May 18, 2022

**Re: Cutters Edge/ Office/ Warehouse**  
**820 Rankin Rd. NE**  
**Traffic Circulation Layout**  
Architect's Stamp 05-03-22 (G15-D049)

Based upon the information provided in your submittal received 05-16-22, the above referenced plan cannot be approved for Building Permit until the following comments are addressed:

A
A1.3
SOLID WASTE
1" = 20'-0"

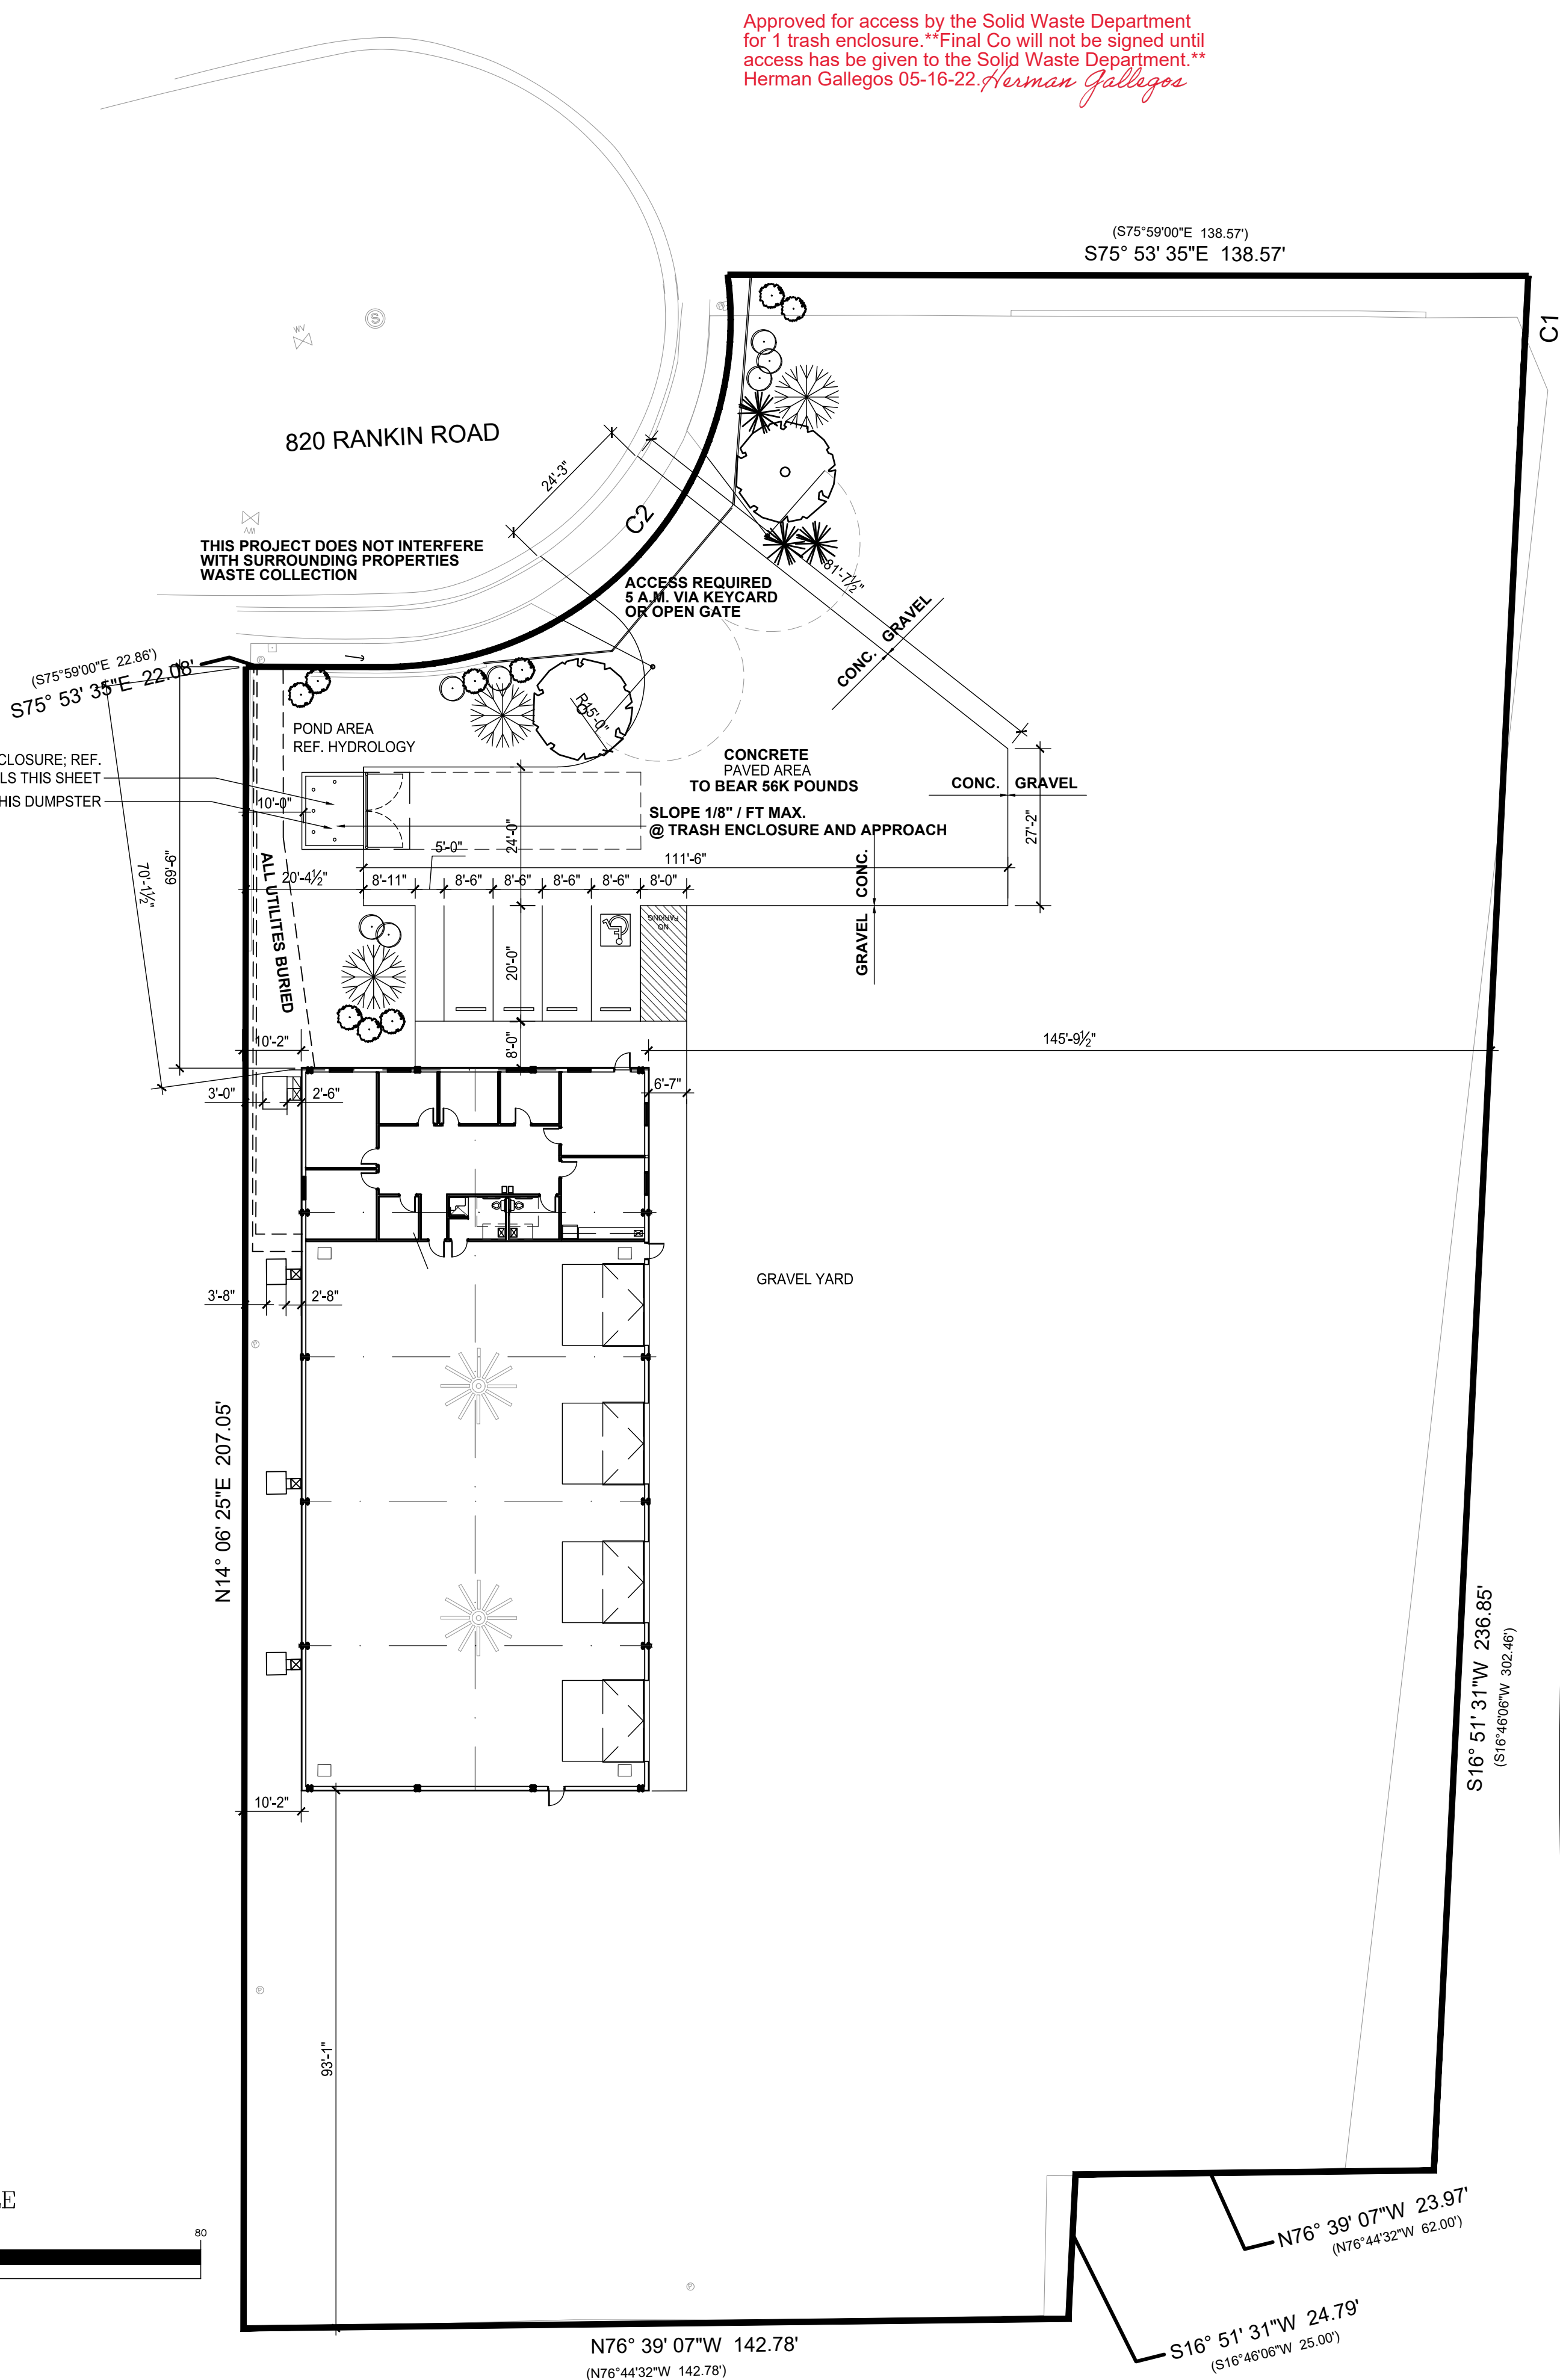
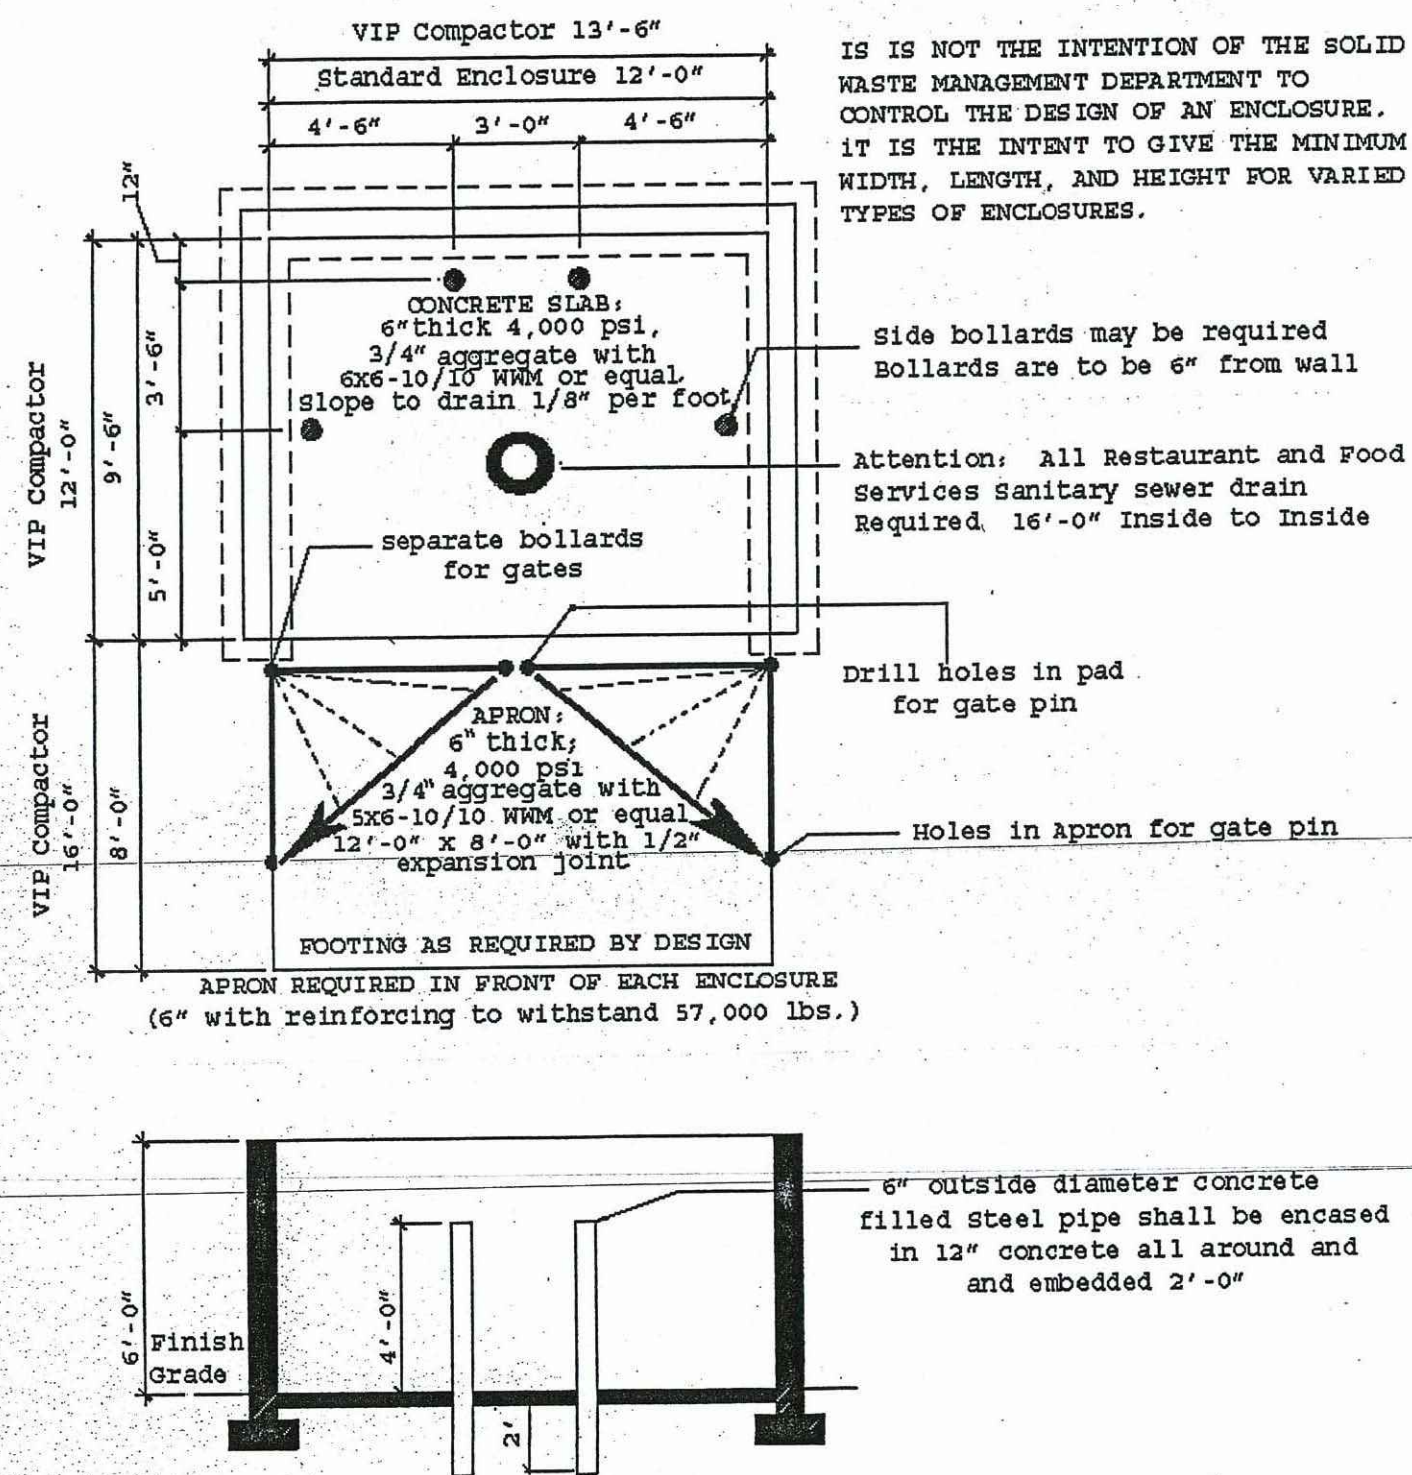
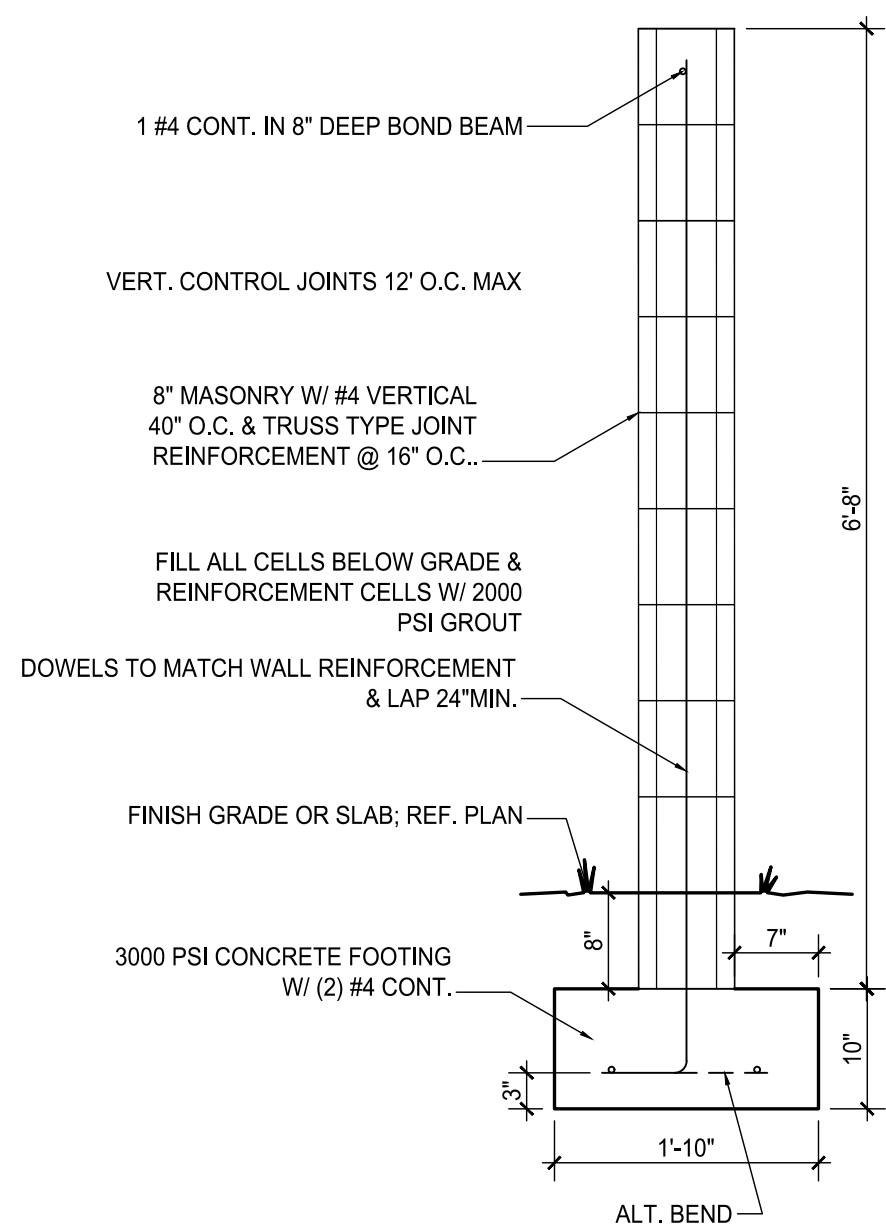
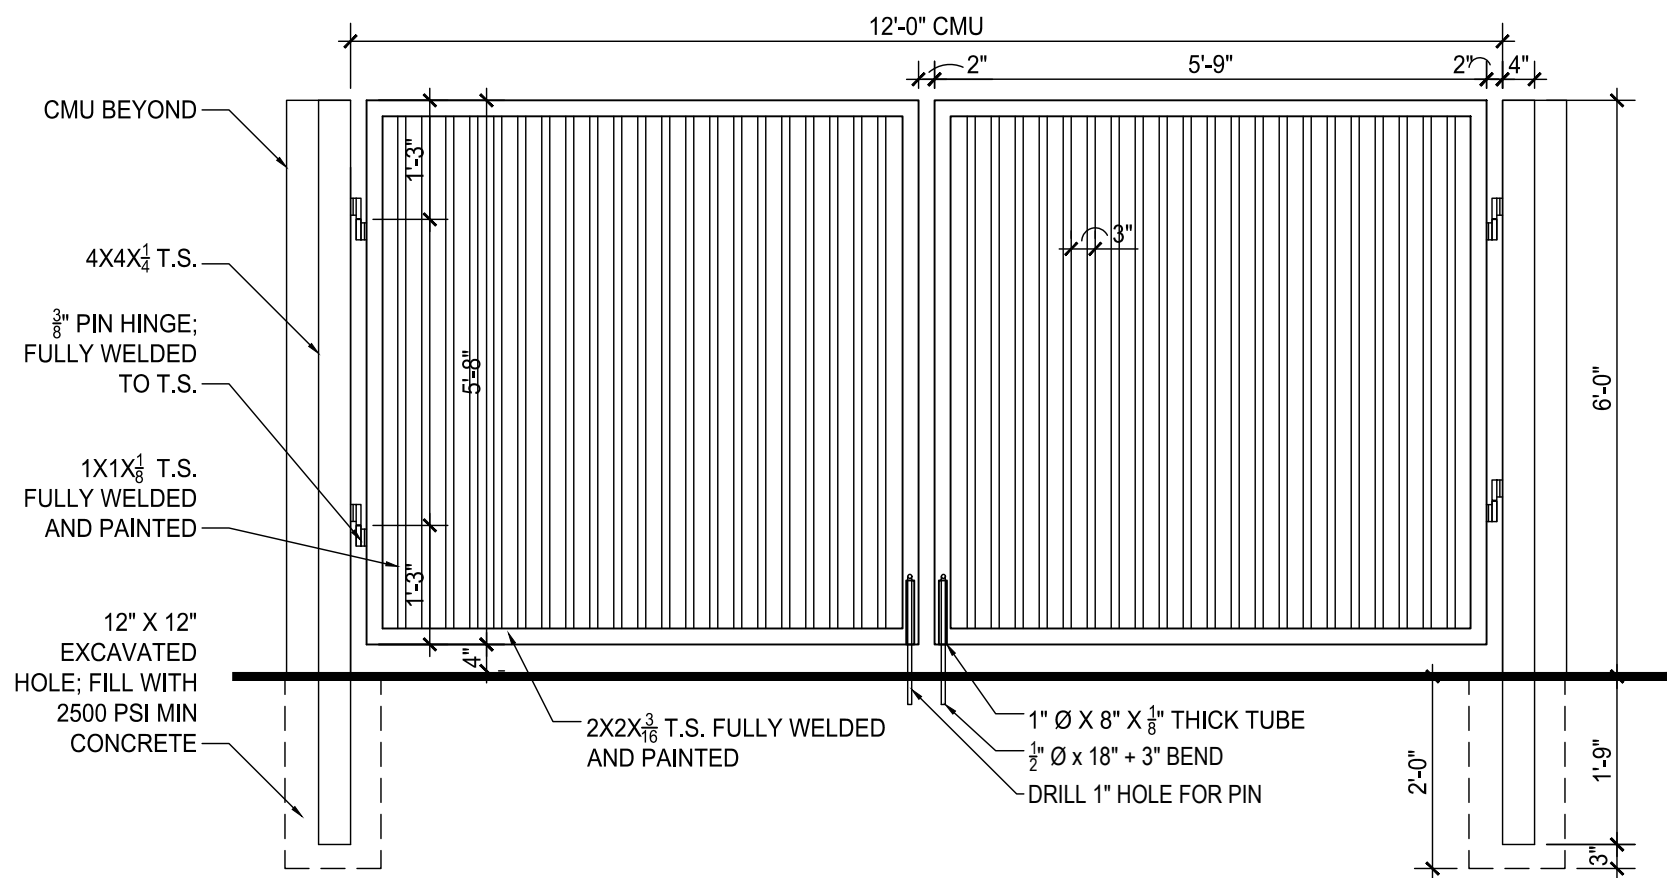
19. Refuse vehicle maneuvering shall be contained on-site. The refuse vehicle shall not back into the public right of way.; provide a copy of refuse approval.
